LONGFIELD SOLAR FARM – EN010118

Section 51 advice regarding draft application documents submitted by Longfield Solar Energy Farm Limited

On 18 October 2021 Longfield Solar Energy Farm Limited submitted the following draft documents for review by the Planning Inspectorate as part of its Pre-application Service¹:

PROJECT: Longfield Solar Farm
 TITLE: Works Plan Sheet 2
 CLIENT: Longfield Solar Energy Farm Ltd
 DATE: 15.09.22 SCALE: 1:2,500@A1
 DRAWN: EL DRAWING NO.: 4077_LGF_DR_PRE_0008.2
 CHECKED: RS REVISION: 1

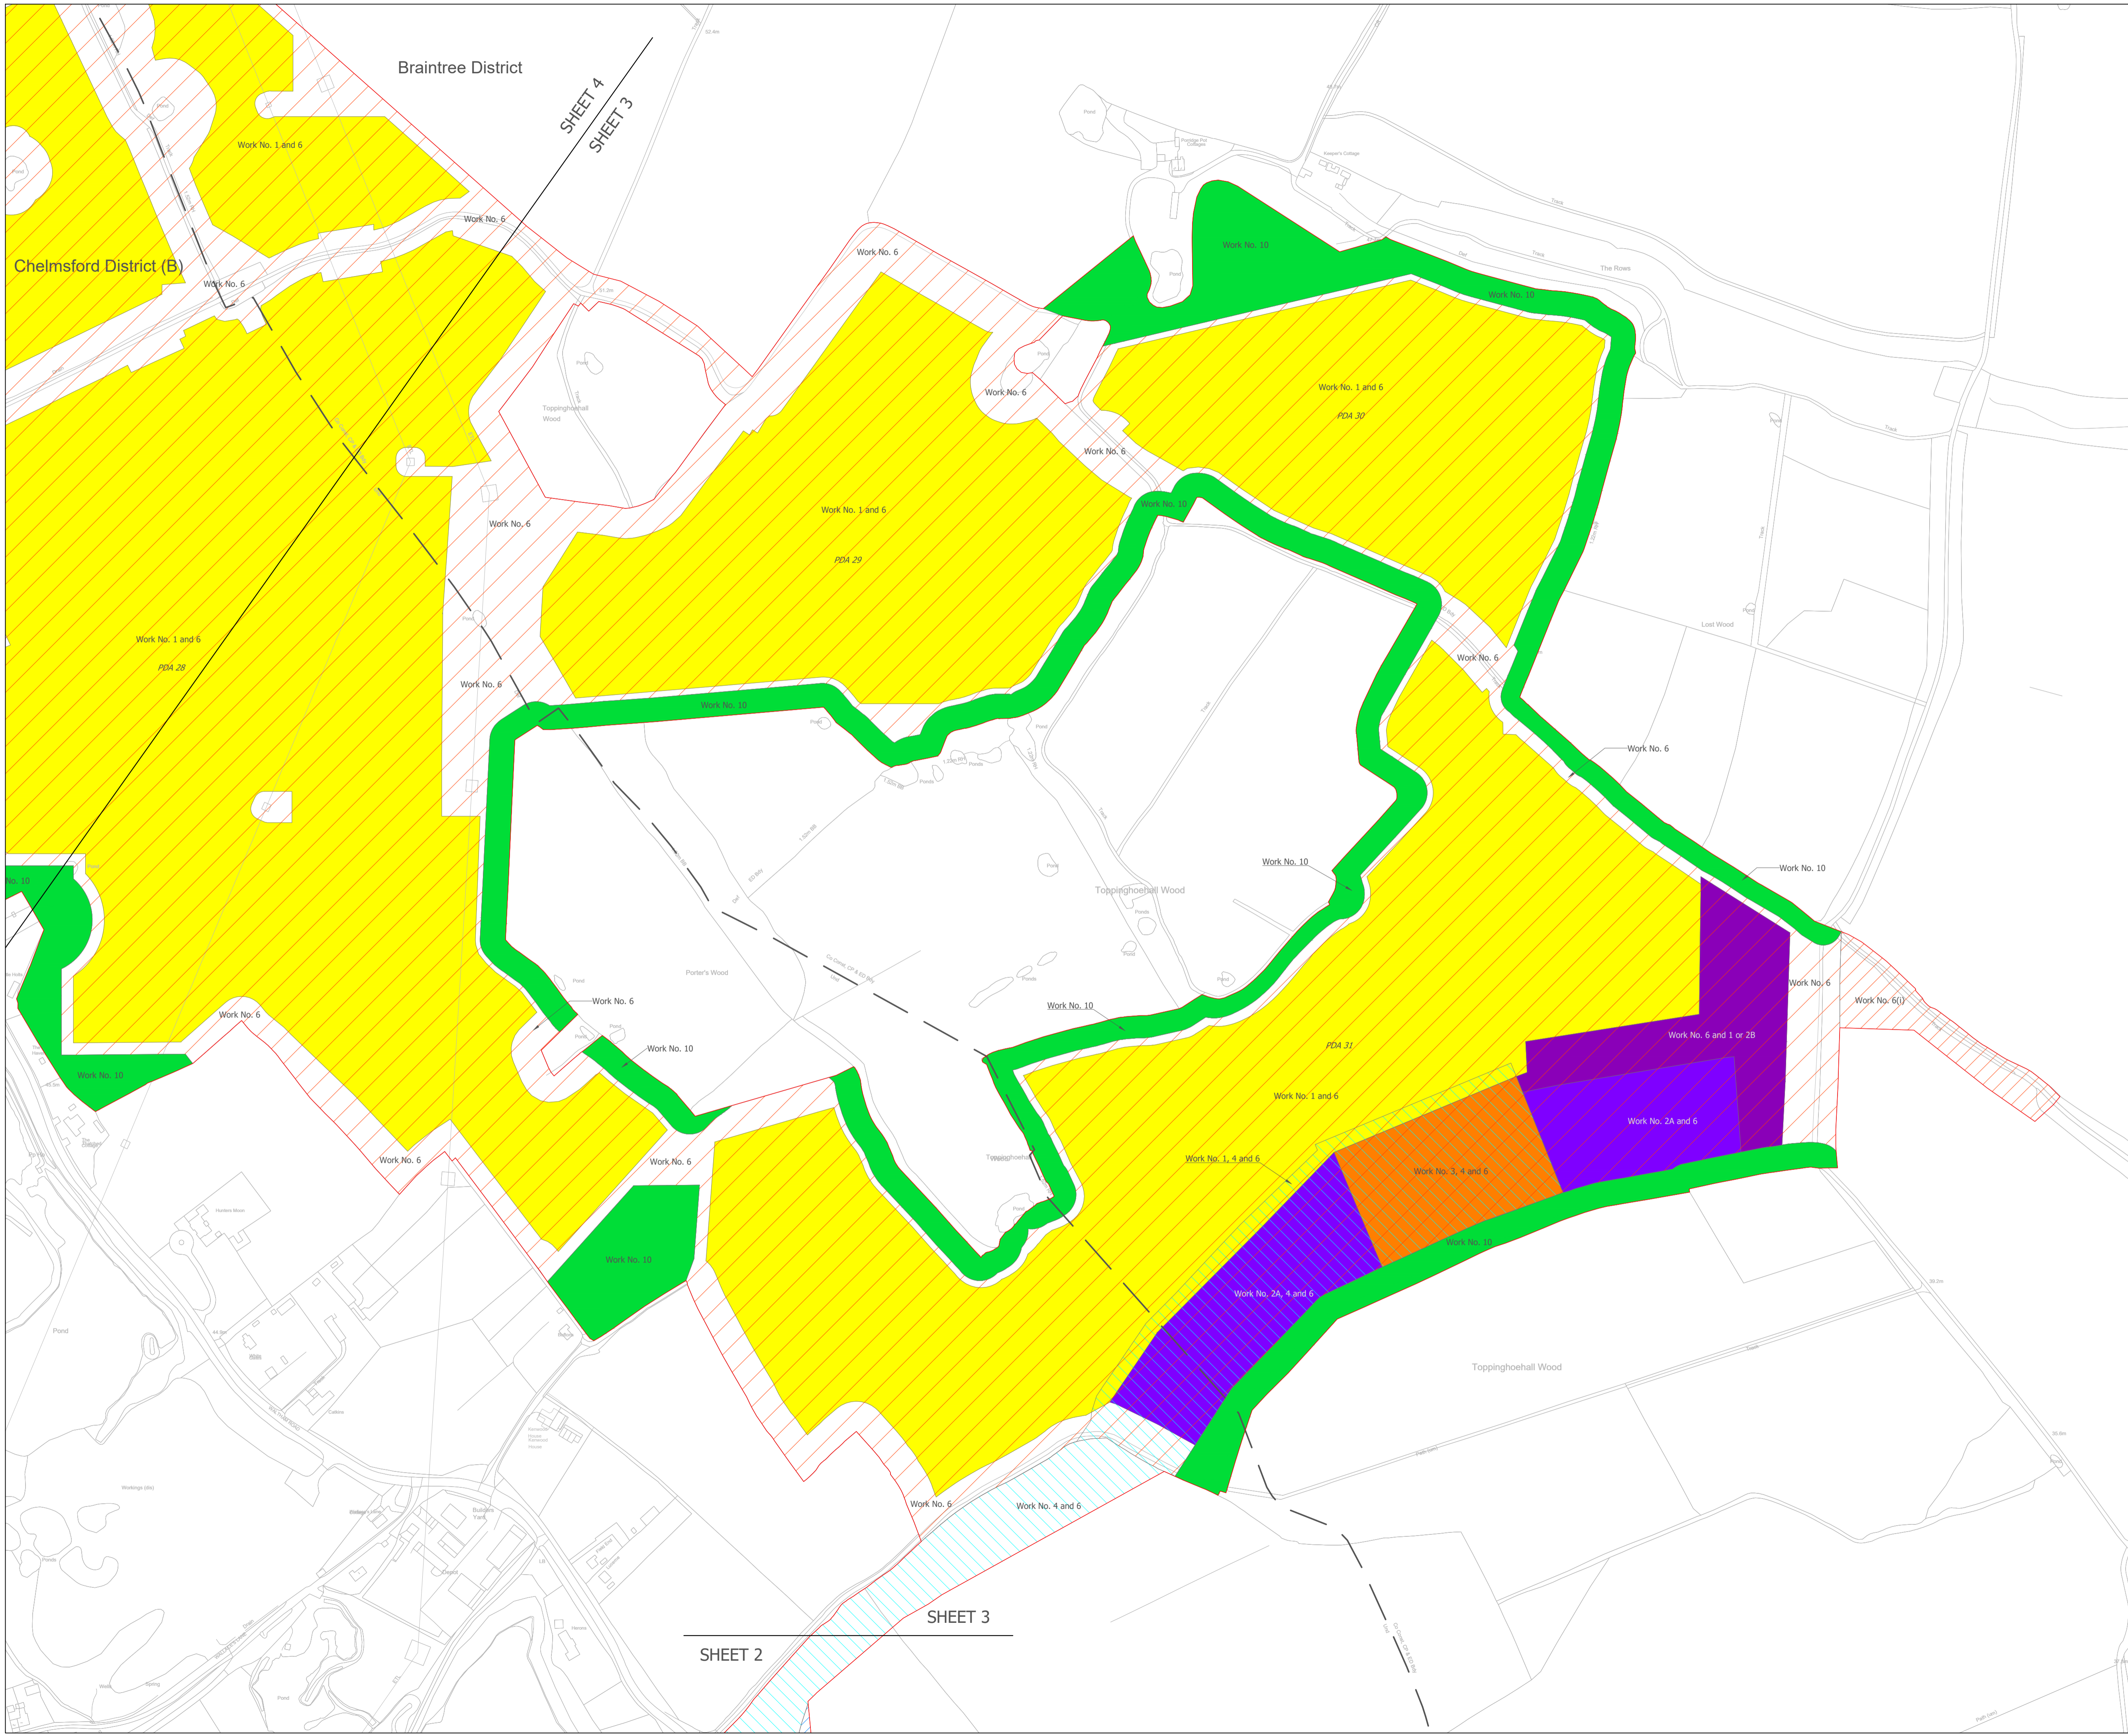
Ref No.	Paragraph/Section	Comment/Question
5.	North arrow	The north arrow on the upper left-hand side of the plan blocks part of the "Works area 10" highlighted in green. Although this part is visible in <i>Works Plans0008.1 DRAFT</i> , it would be convenient that the north arrow was moved so that the Order Limit border is consistent during all of the work plans.

PROJECT: Longfield Solar Farm
TITLE: Works Plan Sheet 4
CLIENT: Longfield Solar Energy Farm Ltd
DATE: 15.09.22 **SCALE:** 1:2,500@A1
DRAWN: EL **DRAWING NO.:** 4077_LGF_DR_PRE_0008.4 **tel:** +44 (0)1904 715 470
CHECKED: RS **REVISION:** 1

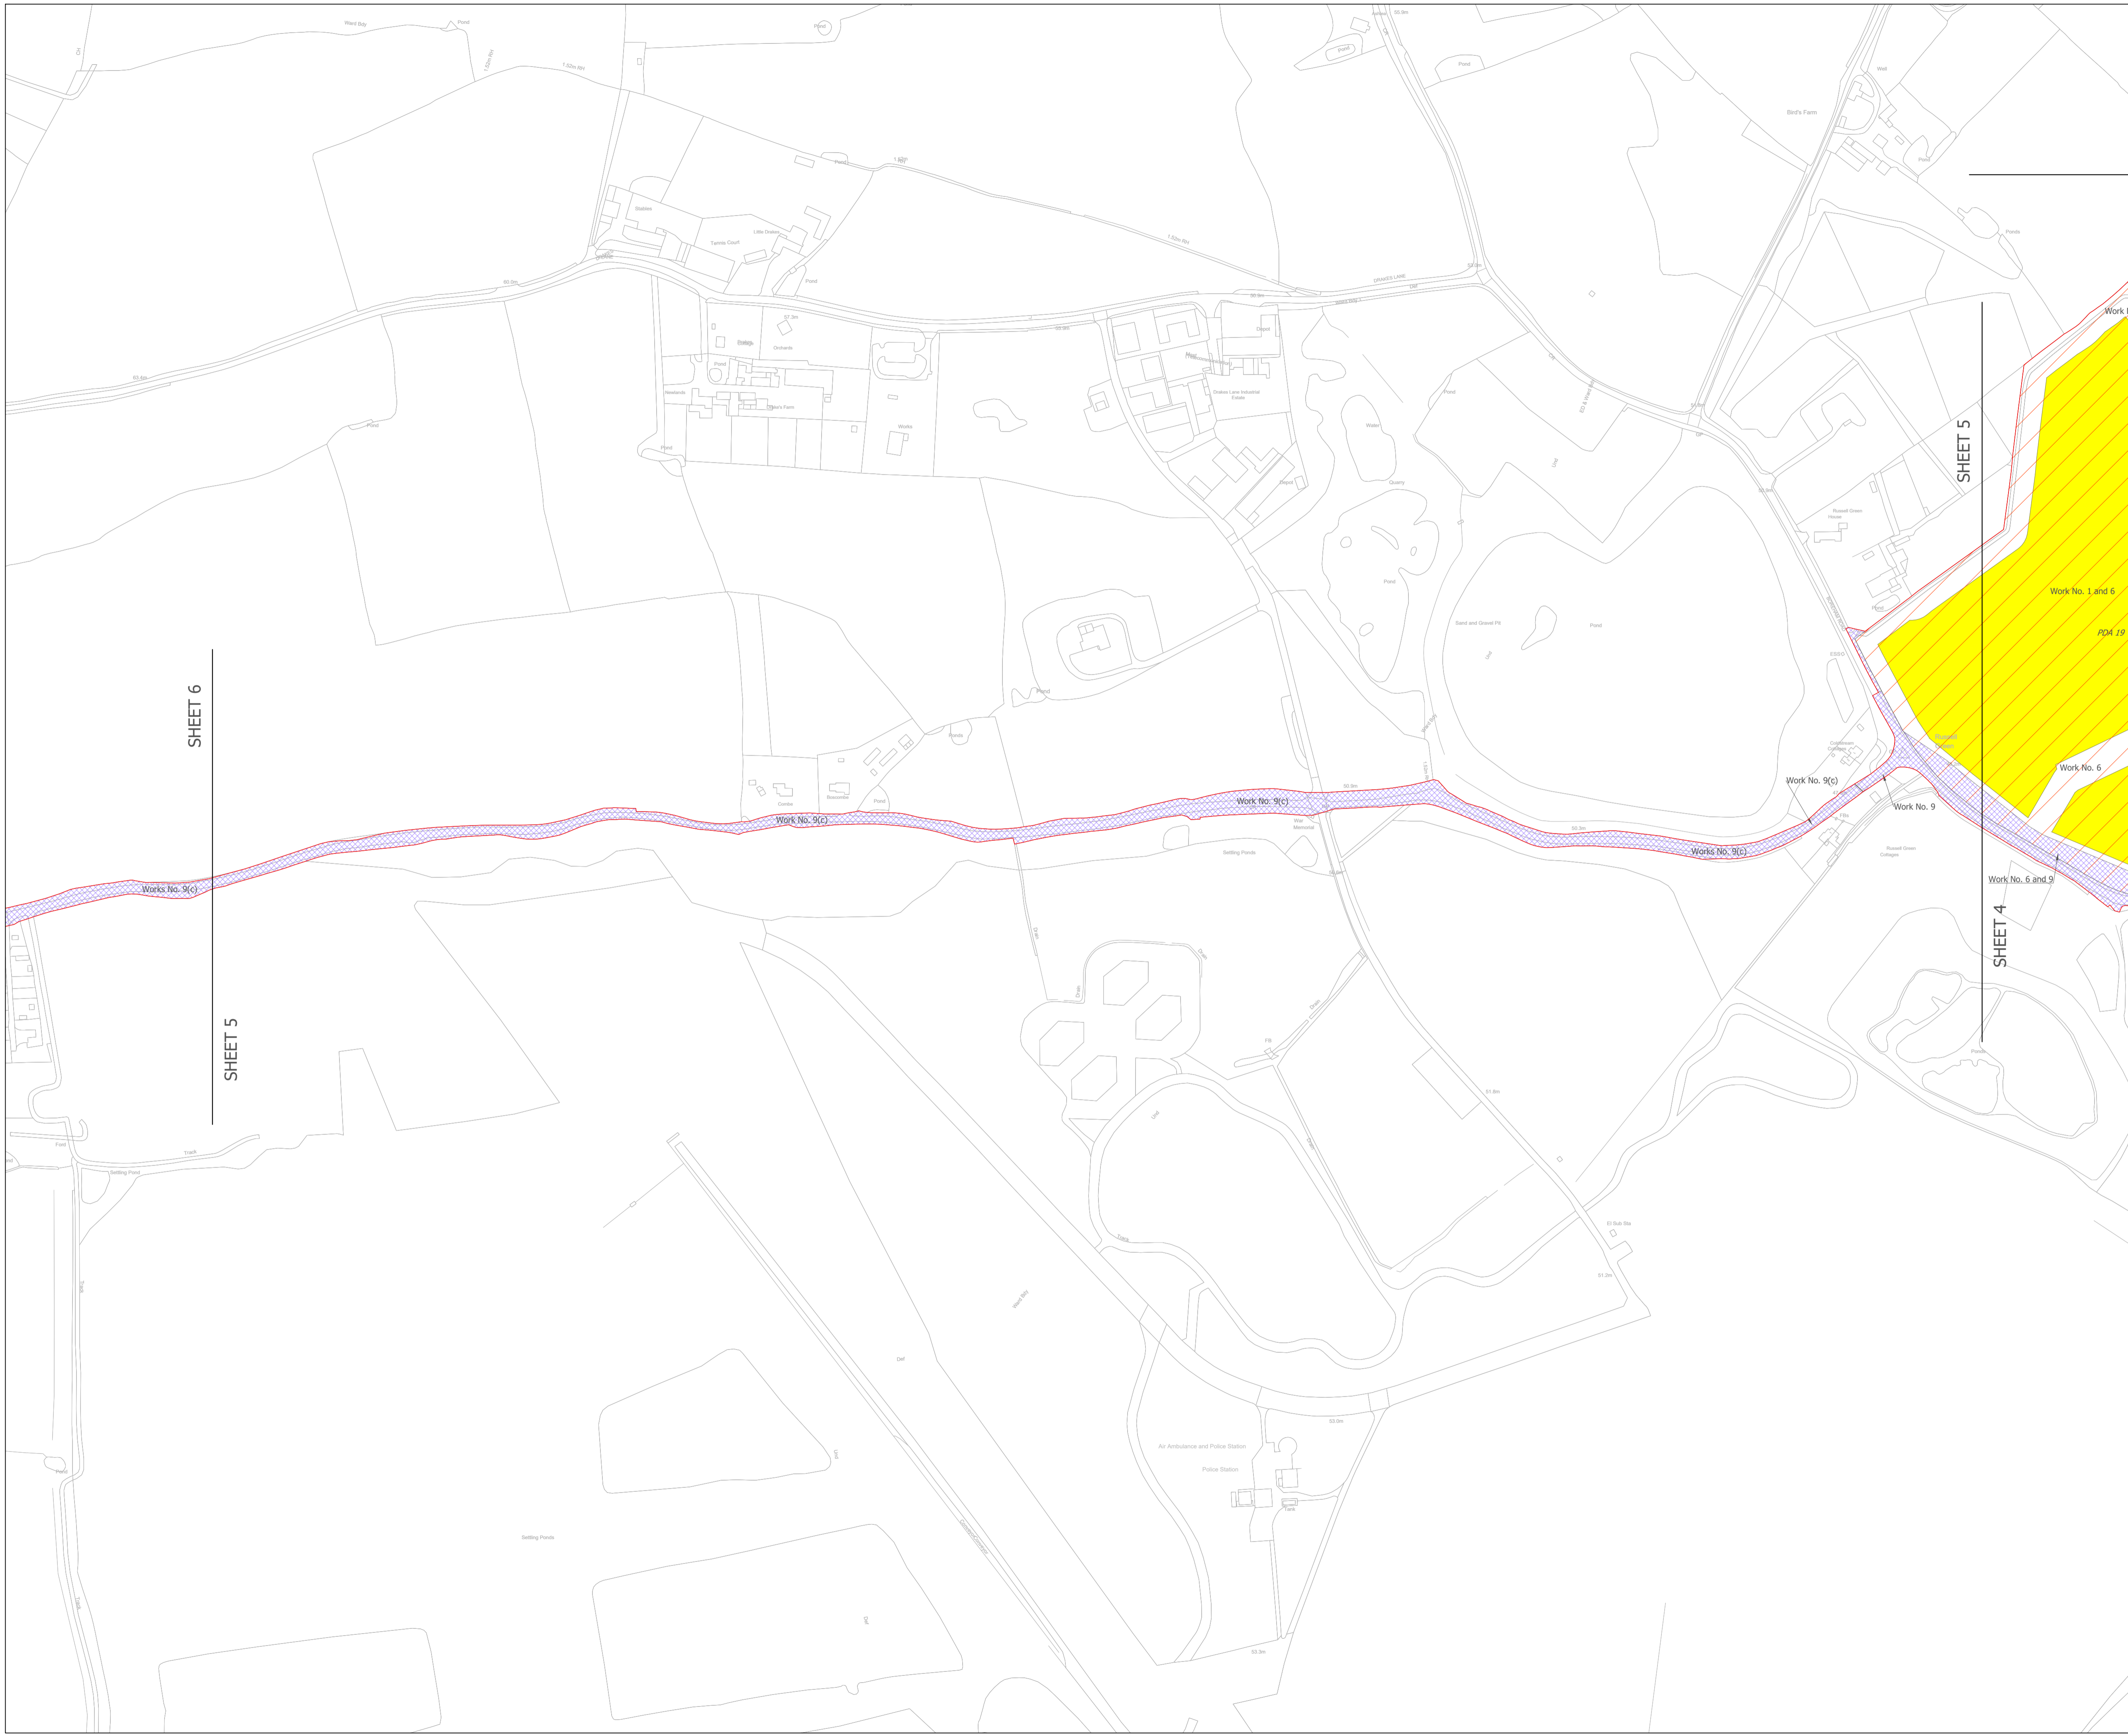
Ref No.	Paragraph/Section	Comment/Question
6.	Key - Works Area 8	The "Work Area 8" key is included within this document of the plan. However, it is difficult to visualise and the Applicant should consider amending to provide greater clarity.

DRAWN: EL **DRAWING NO.:** 4077_LGF_DR_PRE_0008.5

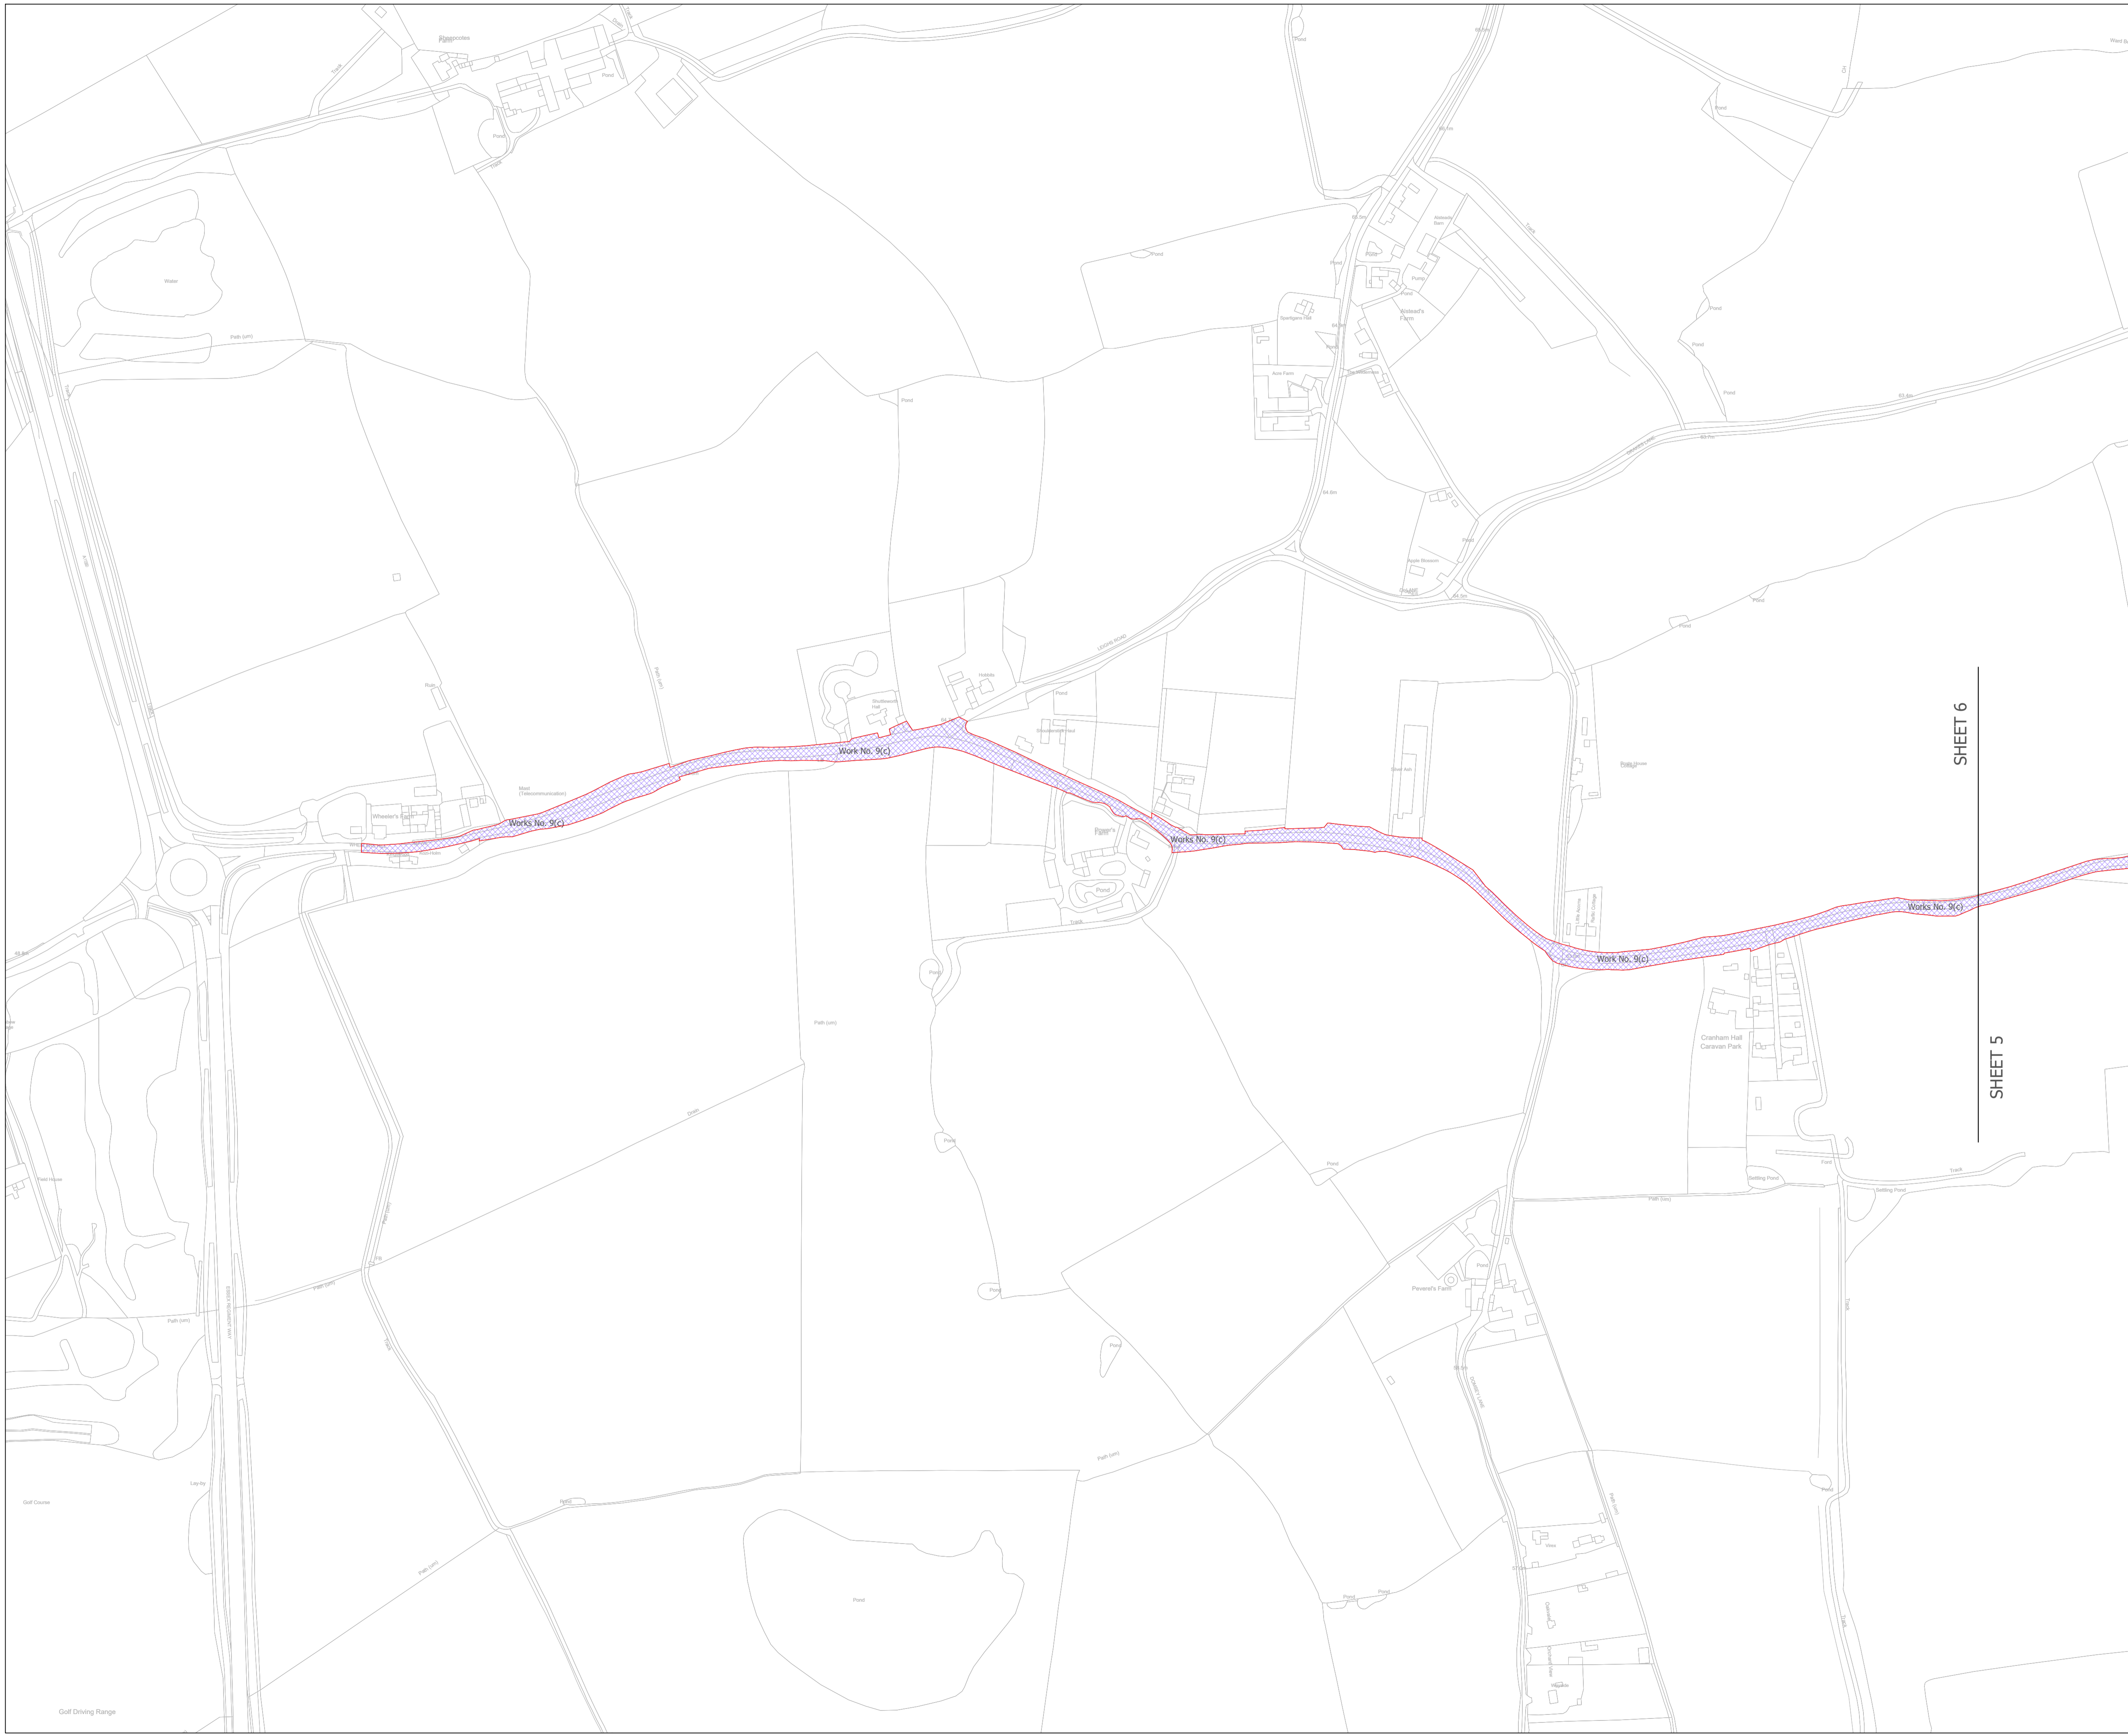
Ref No.	Paragraph/Section	Comment/Question
7.	North arrow	The north arrow on the upper left-hand side of the plan blocks part of the "Works area 1" highlighted in yellow and "Work area 6" highlighted in red stripes. Although Works Areas 1 and 6 are visible on <i>Works Plans0008.4 DRAFT</i> , it would be helpful if the north arrow was moved so that the work limit is fully visual on the Works Plan.
